# Submittal Record

Submittal #	283100.001
Cycle	1
Sub-Section	
Description	Fire Alarm
Type	Shop Drawings
Status	Open
Copies	
Subcontractor	SOUTH-FAIR ELECTRIC CONTRACTORS, INC
Contact Name	Chris Duven
Returned Due Date	12/17/2024

11.25.2024	ORIGINAL RELEASE	A
DATE	DESCRIPTION	REVISION
PROJECT:	DUNN OPERATIONS CENTER – OPERATIONS BUILDING 1269 JONESBORO RD HARNETT COUNTY N.C. 28334	
FLOOR NUMBER:	OPERATIONS BUILDING	
DRAWING TITLE:	FIRE ALARM NOTES, LEGEND & RISER DIAGRAM	
SEAL & SIGNATURE:	SHEET #:	1 OF 4
	DRAWN BY:	M.H.
	CHECKED BY:	M.H.
	WO#:	
	SCALE:	AS NOTED
	CONTACT:	
	DRAWING NO.:	<b>FA-001</b>

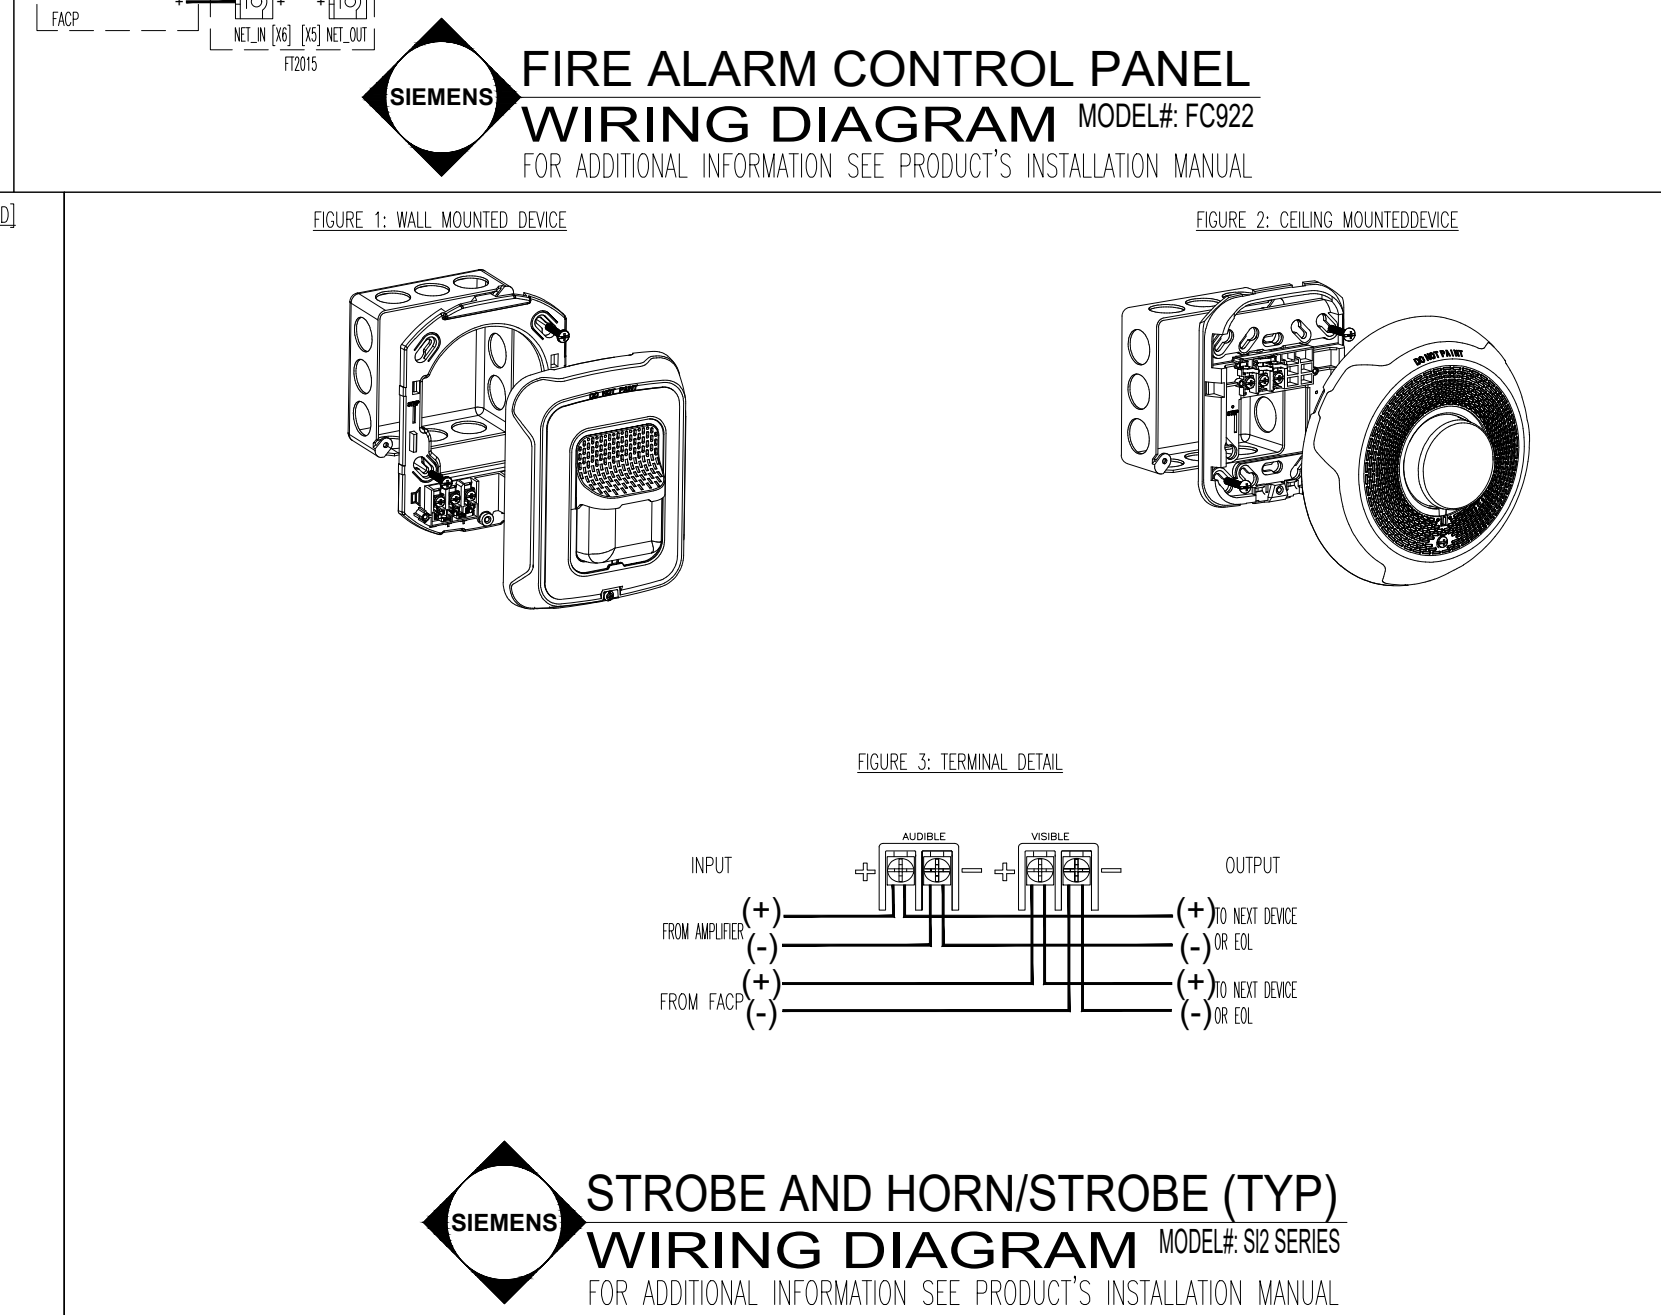
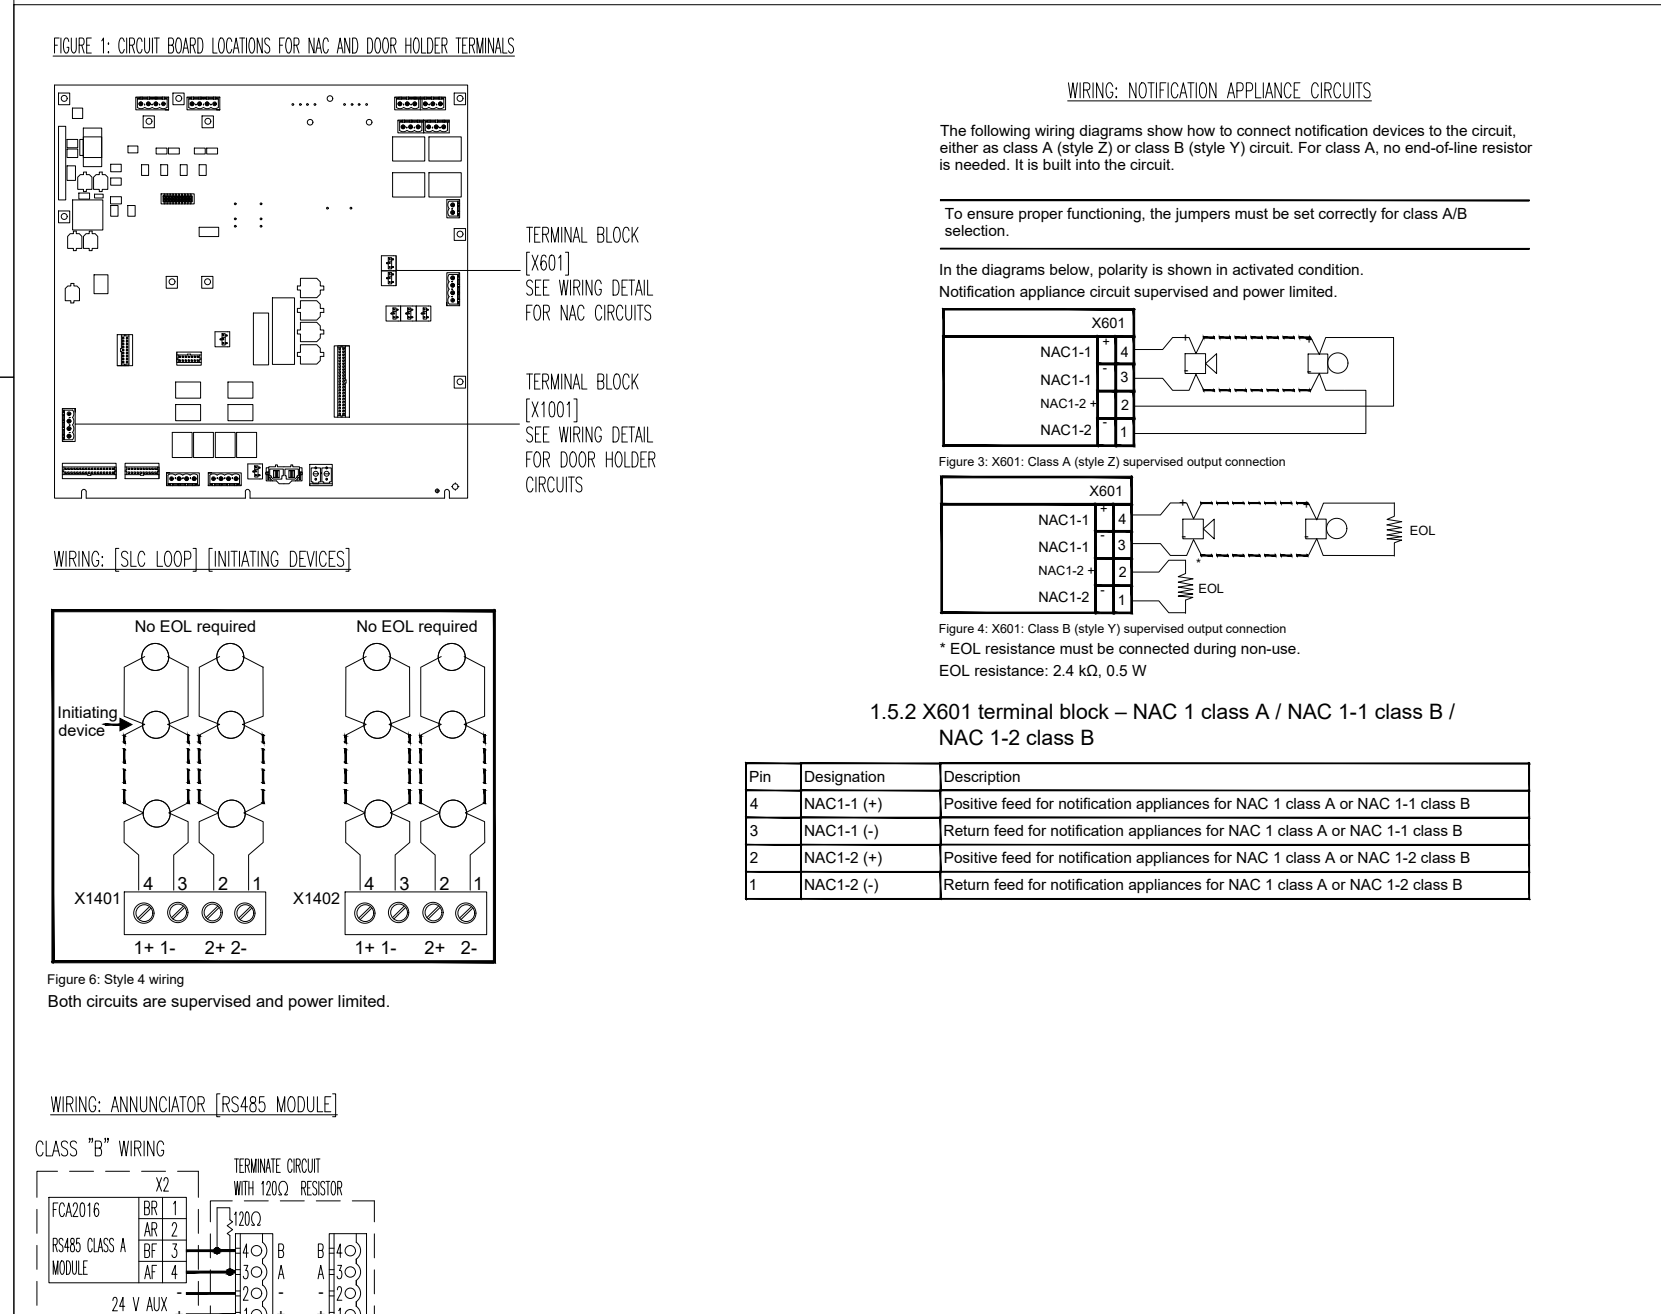
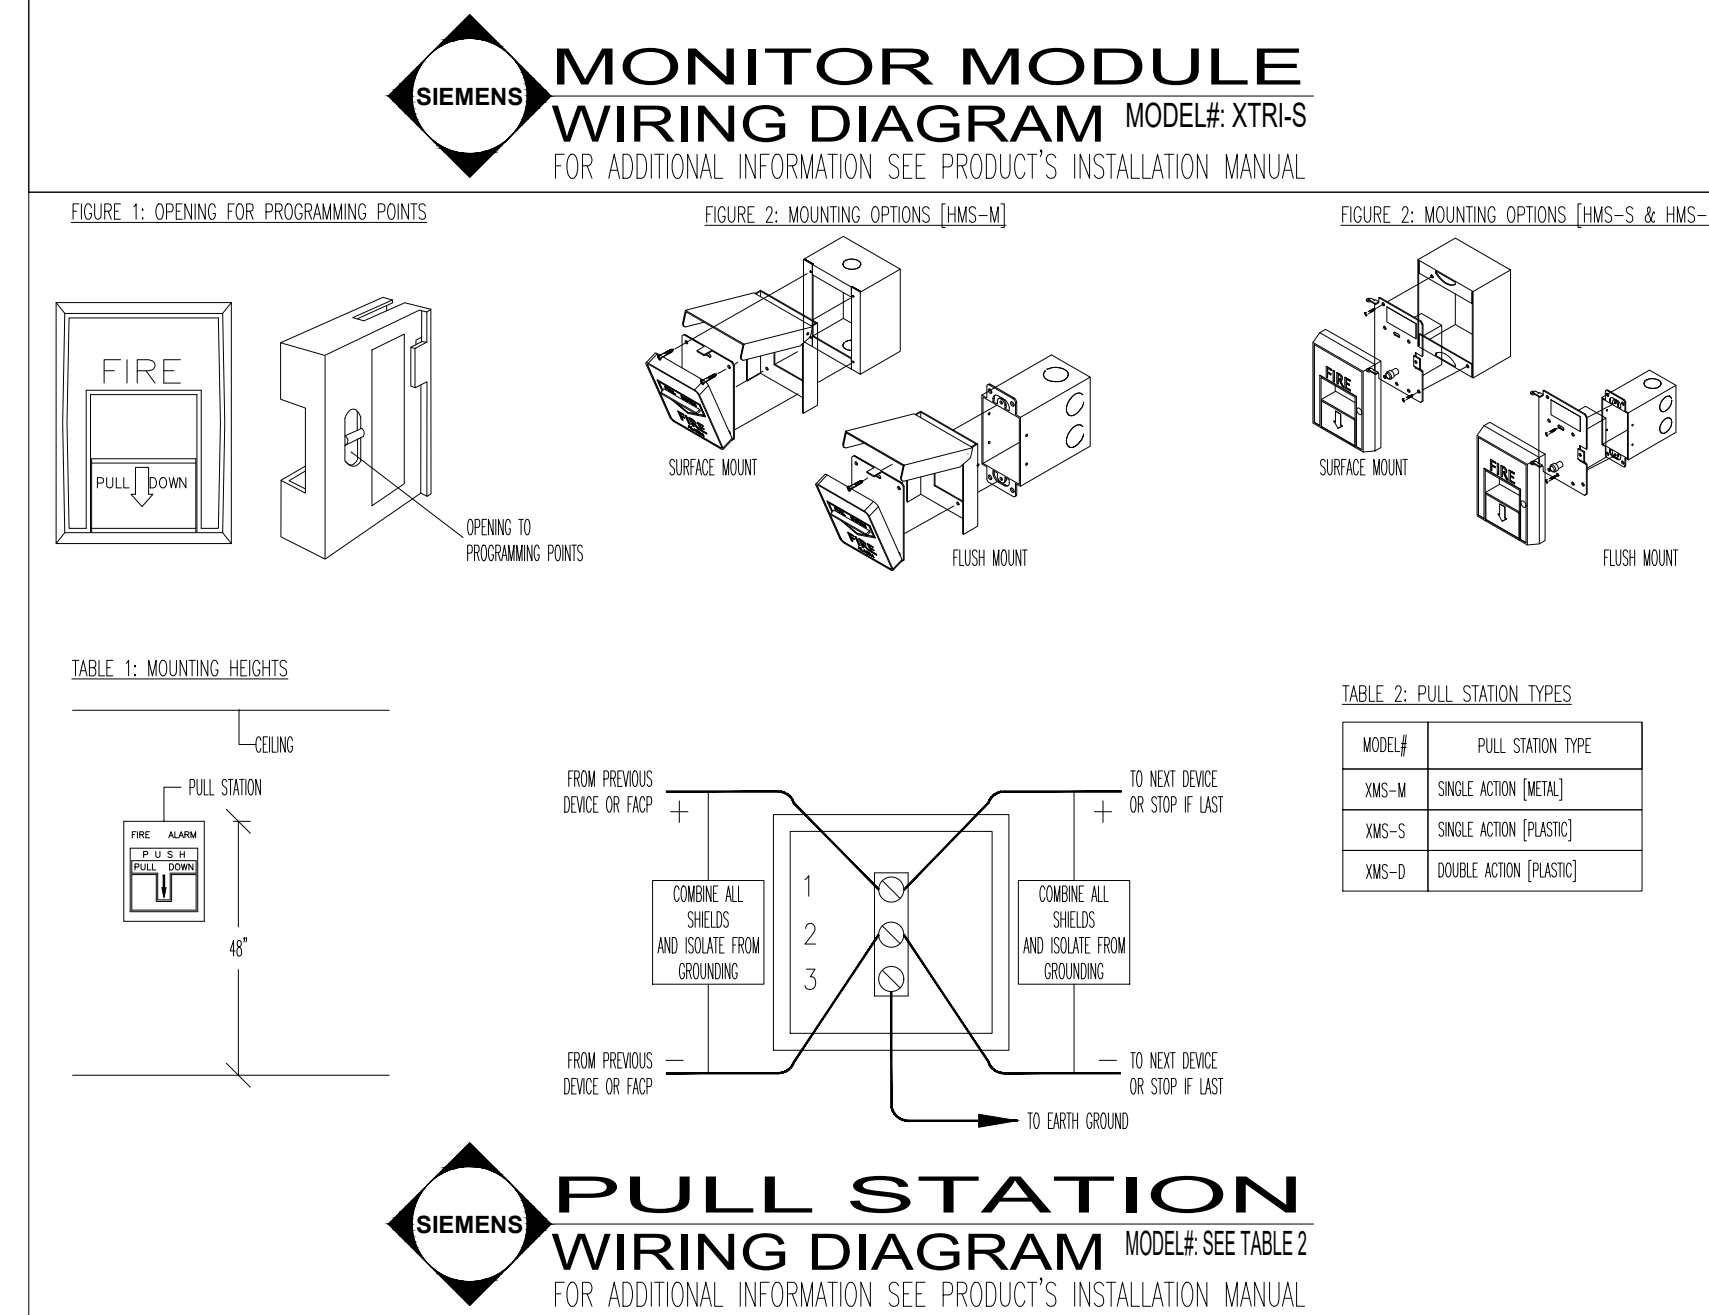
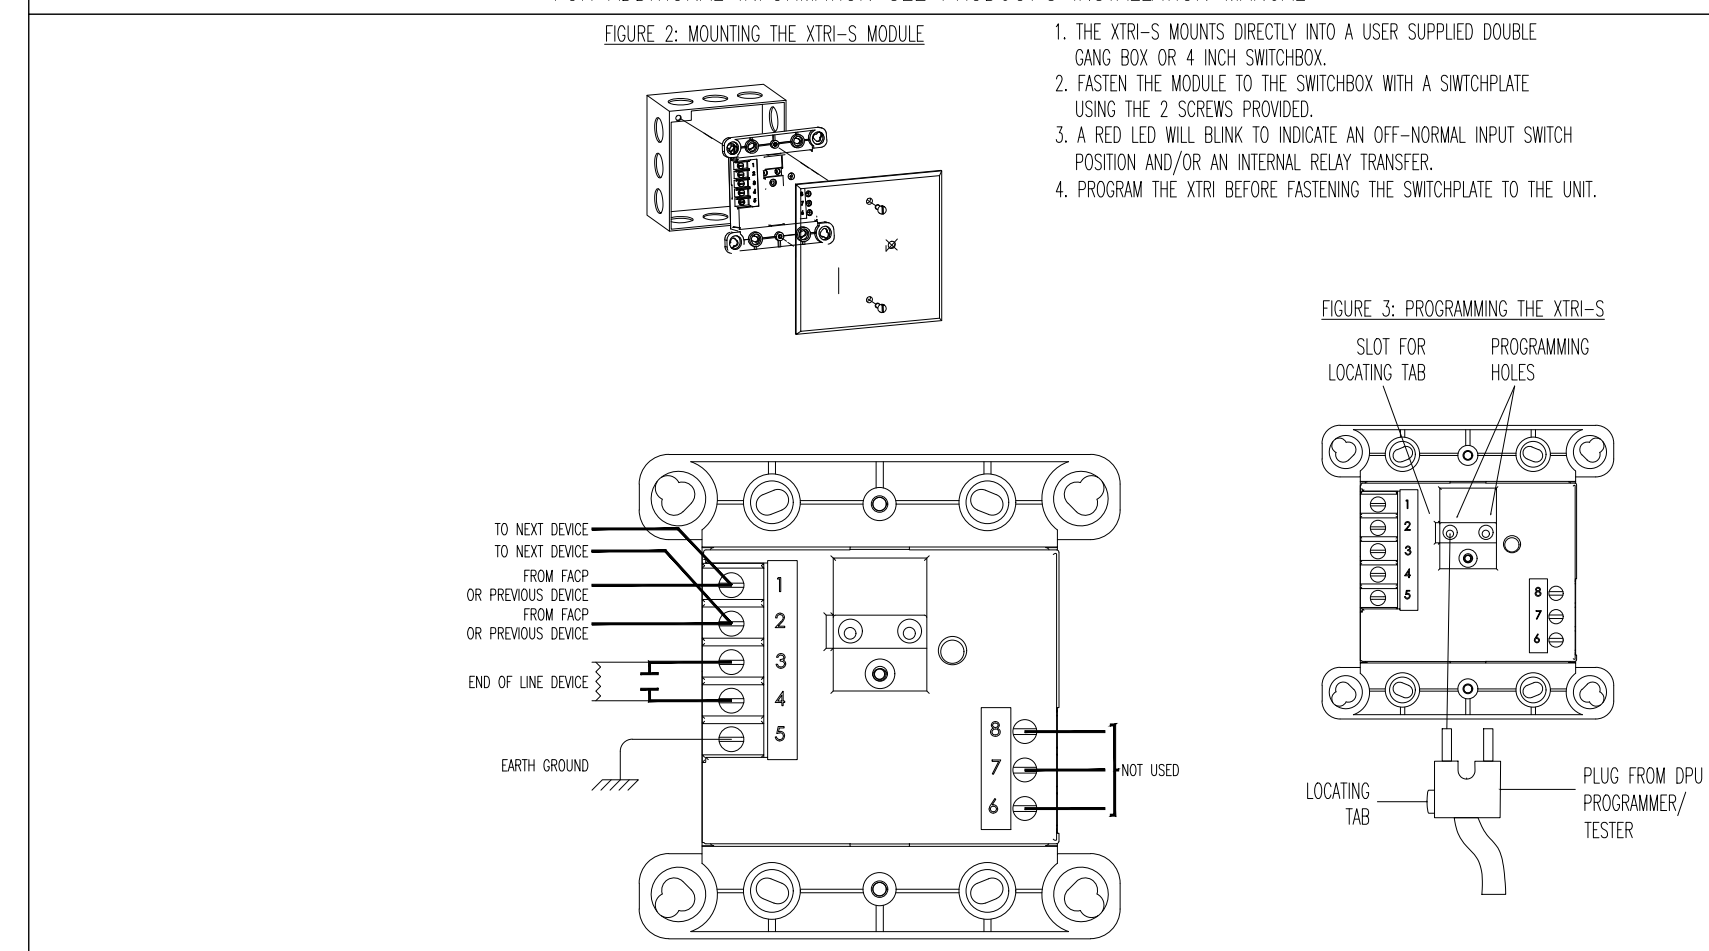
BWA(AMR): LOCATE SMOKE DETECTOR ABOVE ELECTRICAL GEAR.
